Rezoning Transportation Analysis

Petition Number: 2021-092

From: Lakisha Hull, AICP, LEED AP BD+C

Date	Description
06-01-2021	First Review (KP)
08-23-2021	Second Review (KP)
10-22-2021	Third Review (KP)

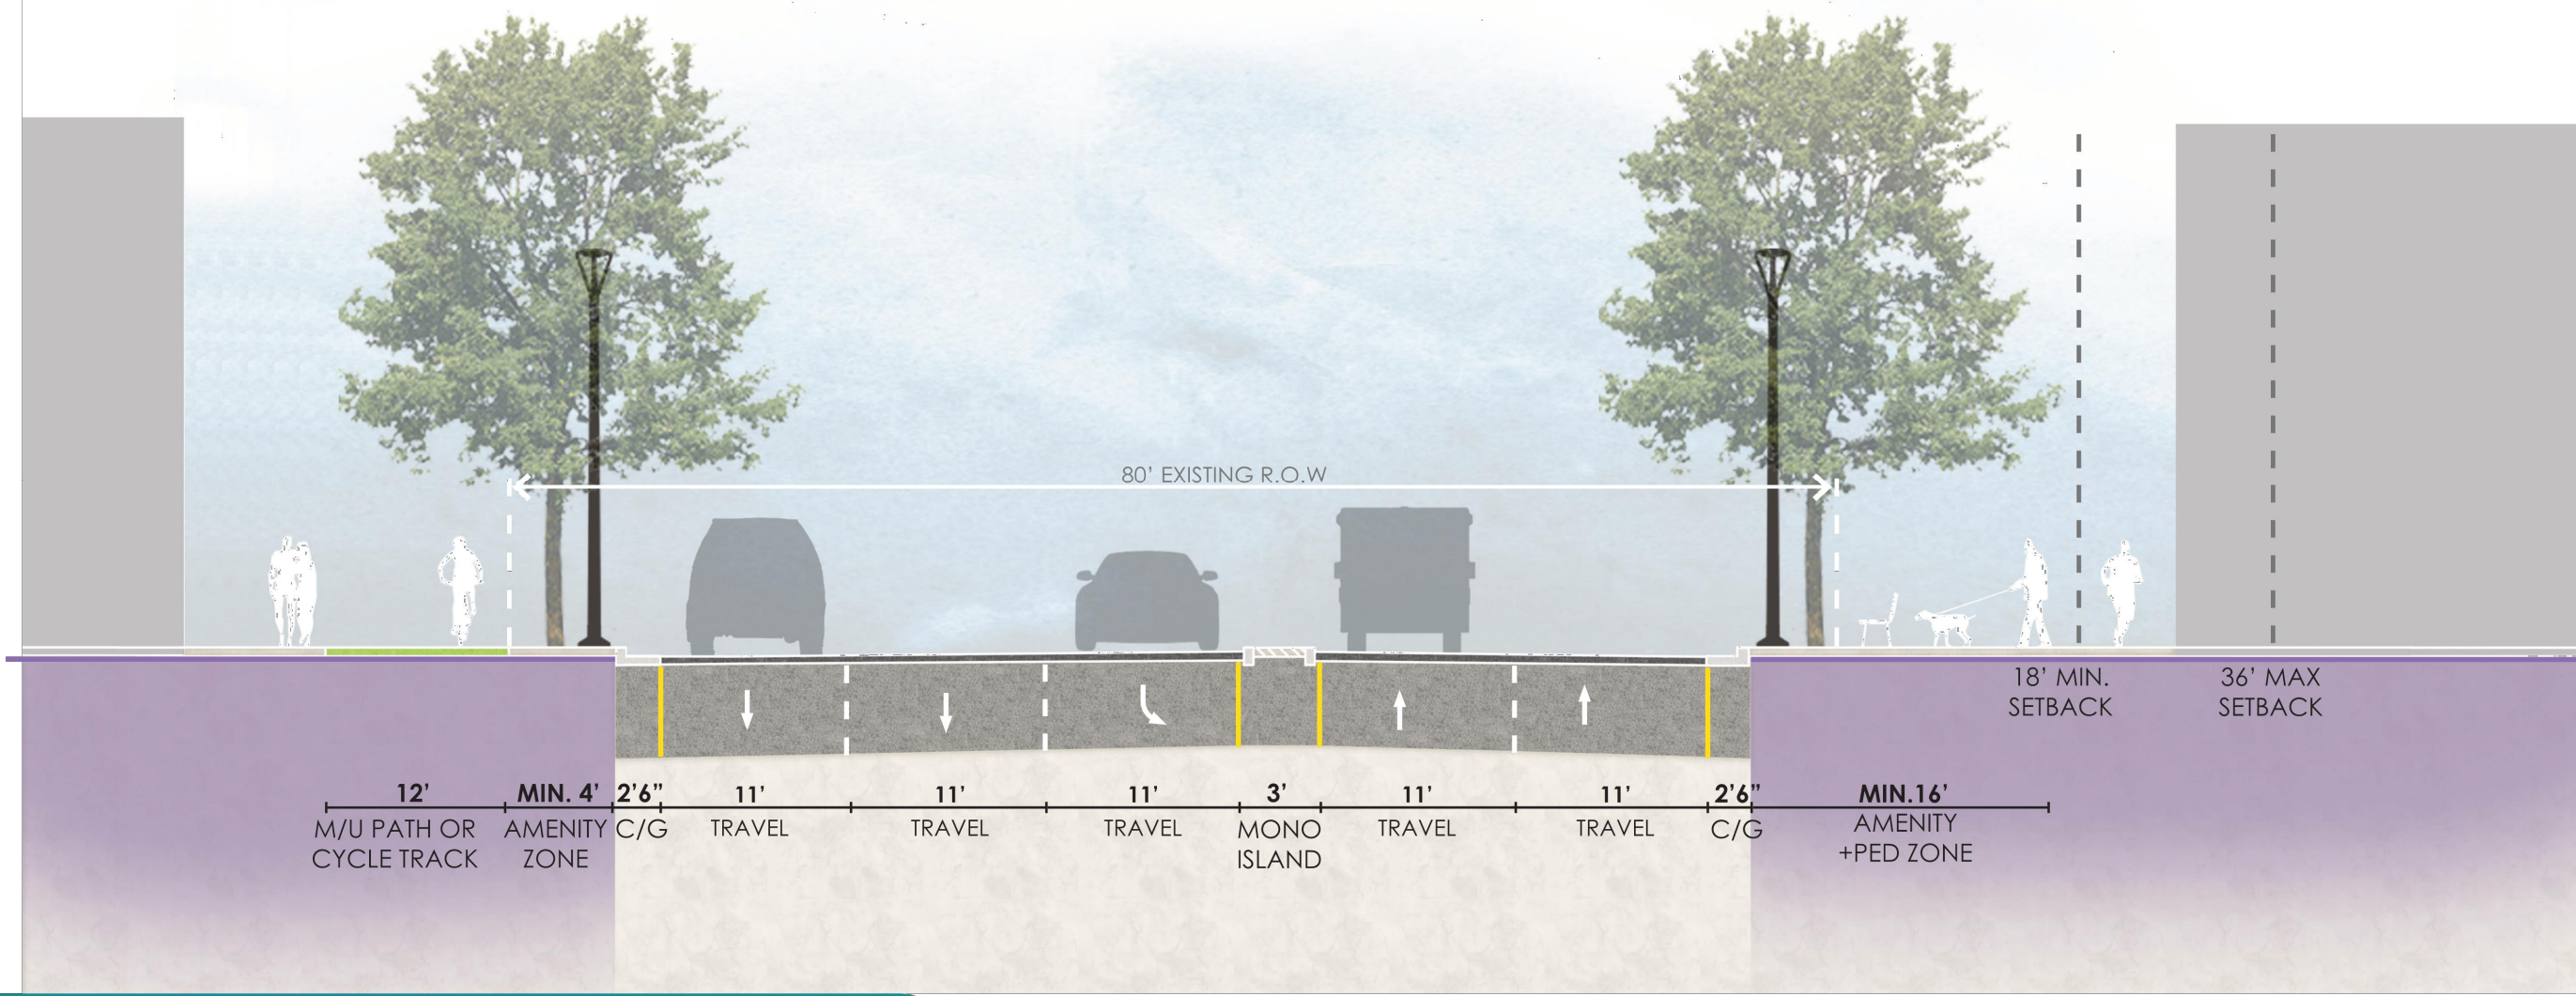
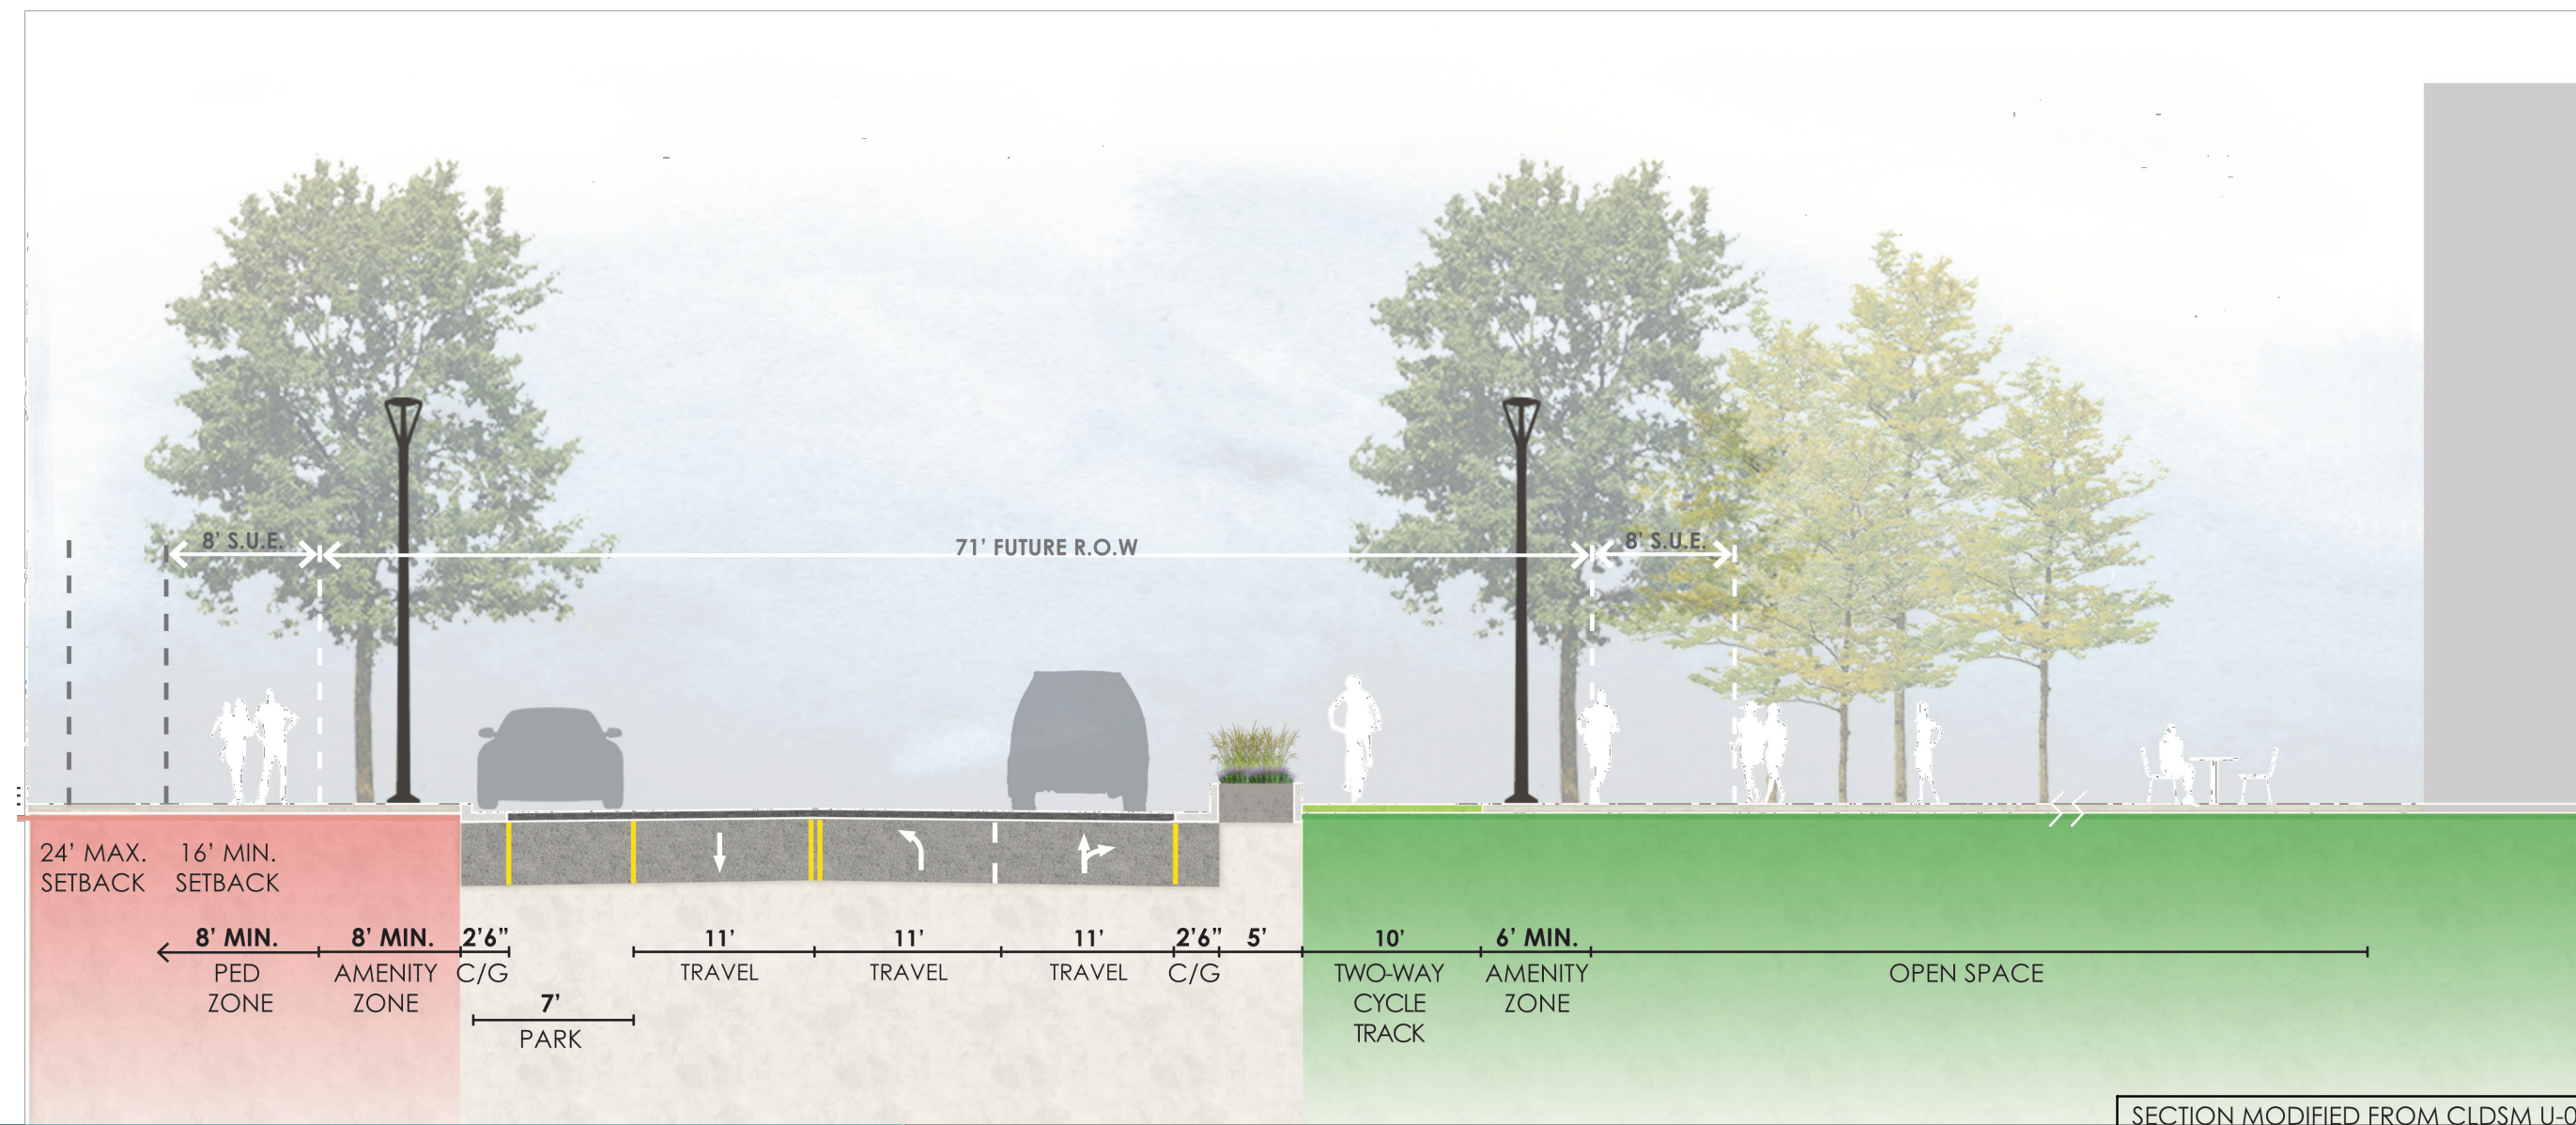
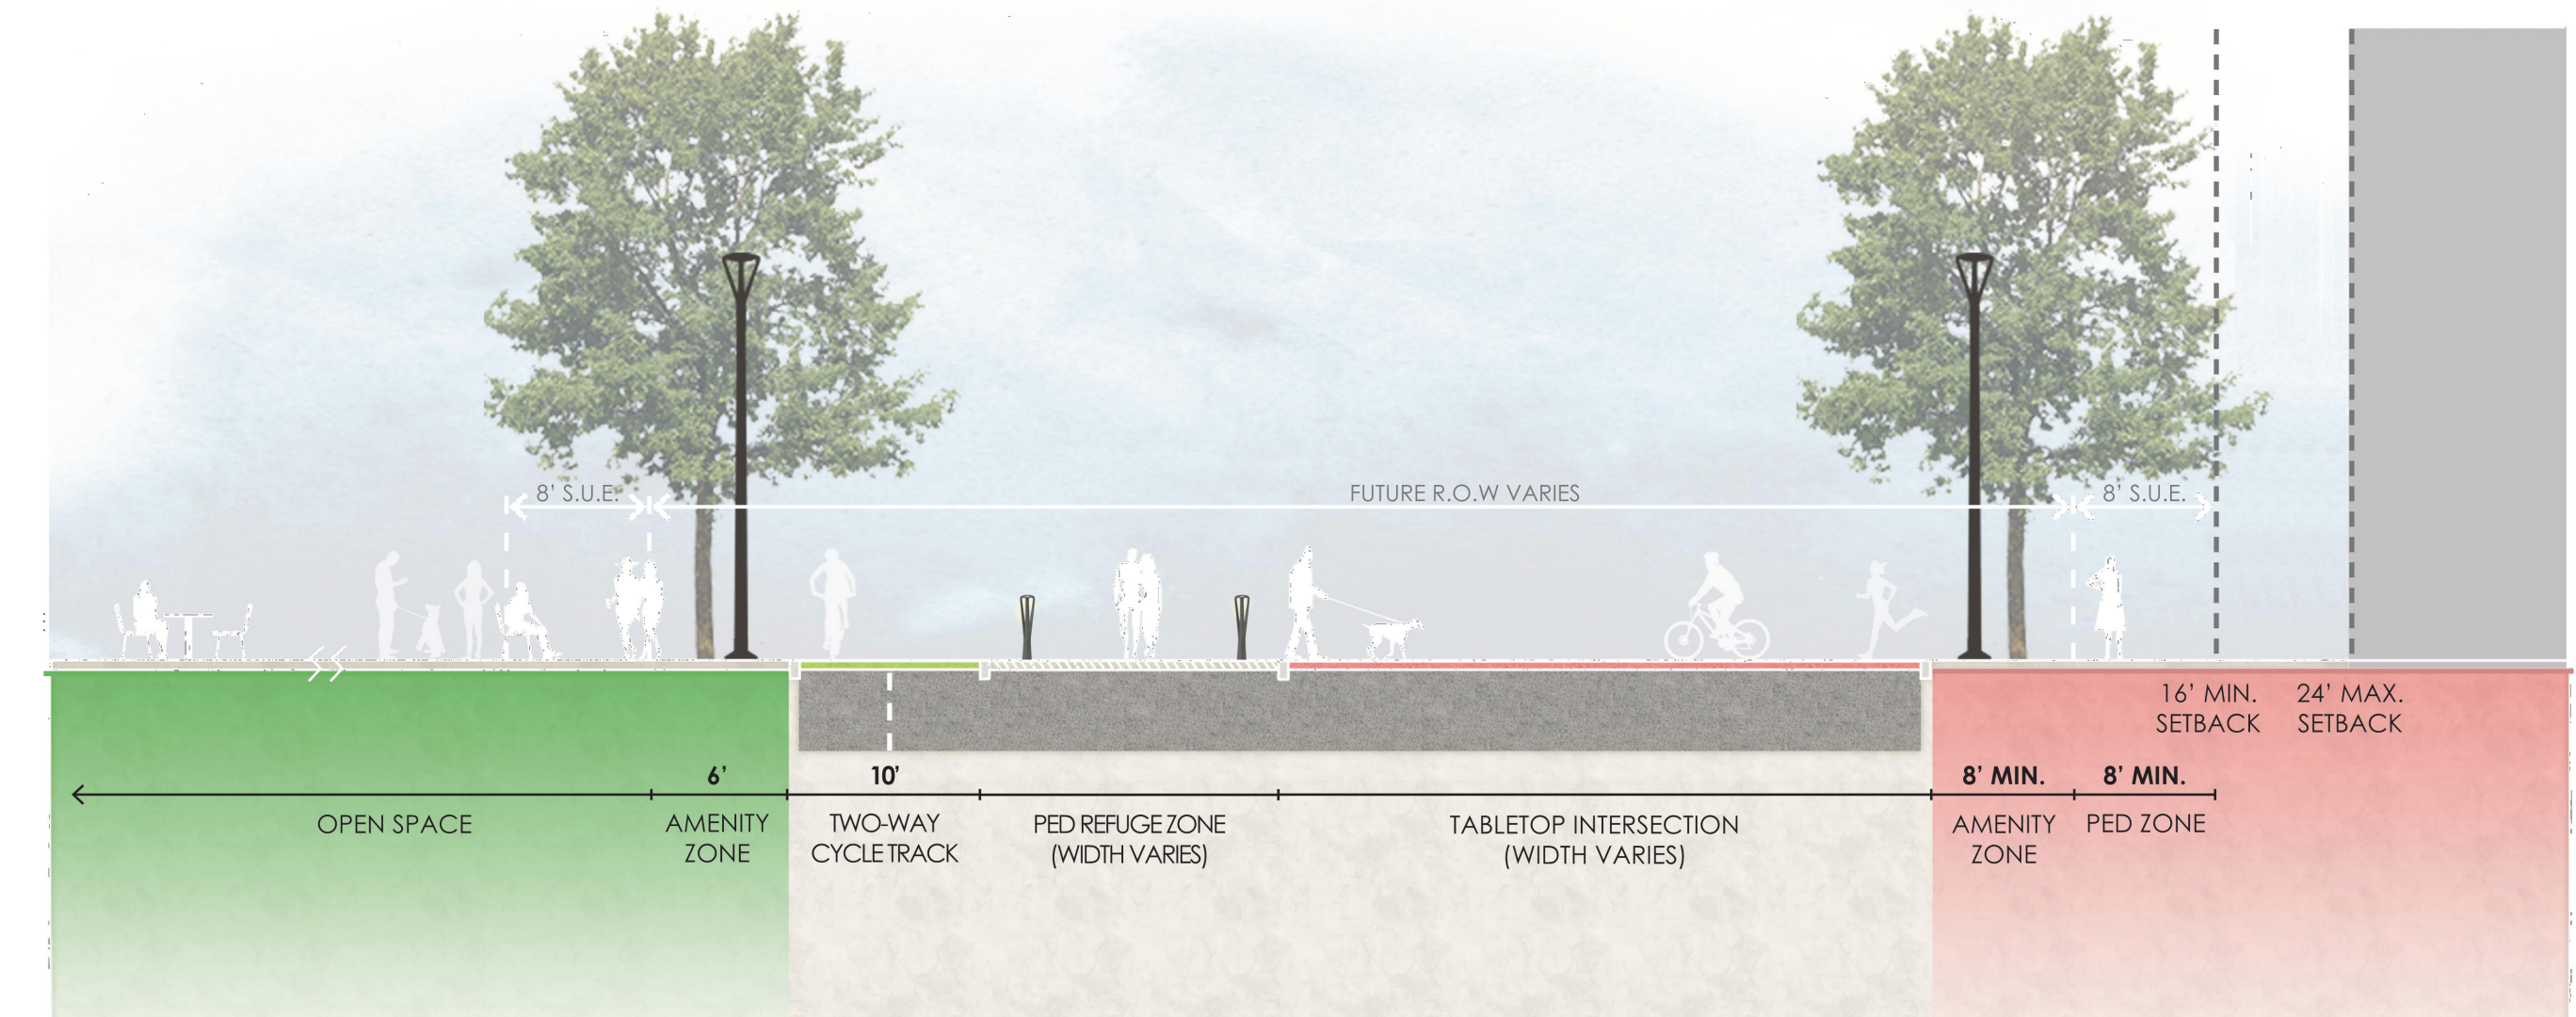
- Curb line:** ~~The proposed zoning district has a setback measured from back of the existing or proposed future curb line. Revise Sheet RZ 1.1 by adding the curb line dimensions to the cross sections provided. Please note: The following curb line dimensions proposed are conceptual and may be altered as coordination with CDOT throughout the rezoning process ensues.~~

- ~~**Morehead Street:** The location of curb and gutter will be moved and located 38-feet from the existing centerline to the back-of-curb. (Revise Site Plan Dated: 10.12.21) Update to comply with Chapter 20 sidewalk and planting strip requirements.~~

- ~~**McDowell Street:** The future location of curb and gutter is in the existing location.~~
 - ~~**Baxter Street (Section C-C)** – The location of curb and gutter will be moved and located to 21.5 feet from the existing centerline to each back-of-curb.~~

- ~~**Baxter Street (Section D-D)** – The location of curb and gutter will be moved and located to 19 feet from the existing centerline to each back-of-curb.~~

- ~~**Baxter Street Extension (Section E-E)** – The location of curb and gutter will be moved and located to 21.5 feet from the existing centerline to each back-of-curb.~~

- ~~**Proposed Public Street (Section F-F)** – The location of curb and gutter will be located 18.5 feet from the proposed centerline to each back-of-curb.~~

Update to Comment as a Result of the 08-16-2021 Site Plan:
The proposed and existing back of curb location on Morehead Street must be labeled dimensioned from the existing centerline.

- ~~**Right of way and Other Infrastructure Dimensions:** Revise Rezoning Sheet RZ 1.1 to include detailed dimensions for each infrastructure item, and the total right-of-way for the cross sections shown. Refer to the USDG Cross sections and on street parking details, located within the Charlotte Land Development Standards Manual, to determine the appropriate widths associated with each infrastructure item and the cross sections' total widths. Revise the site plan sheets by clearly labeling each public and private street section as well as each access point. Labeling each street section and access point will allow for thorough comments throughout the rezoning and permitting process. CDOT prefers the separated cycle track and sidewalk for McDowell Street (cross sections A-A and B-B). Please note: The following right of way dimensions proposed are conceptual and may be altered as coordination with CDOT throughout the rezoning process ensues.~~

- ~~**Morehead Street: (10/21/2021 Site Plan) - 56-feet of right-of-way dedication measured from the existing road centerline.**~~
 - ~~**McDowell Street:** 110 feet of total right-of-way dedication, 55 feet measured from the existing road centerline to each right of way line.~~

- ~~**Baxter Street (Section C-C)** – 93 feet of total right of way dedication, 46.5 feet measured from the existing road centerline to each right of way line.~~

- ~~**Baxter Street (Section D-D)** – 86 feet of total right-of-way dedication, 43 feet measured from the existing road centerline to each right of way line.~~

- ~~**Baxter Street Extension (Section E-E)** – 93 feet of total right of way dedication, 46.5 feet measured from the existing road centerline to each right of way line.~~

- ~~**Proposed Public Street (Section F-F)** – 73 feet of total right of way dedication, 36.5 feet measured from the existing road centerline to each right of way line.~~

The proposed and existing Morehead Street right of way dedication must be labeled dimensioned from the existing centerline. **Outstanding comment (10/21/2021 Site Plan) - Revise the site plan conditional notes and legends that all new streets shall be determined as public or private during**
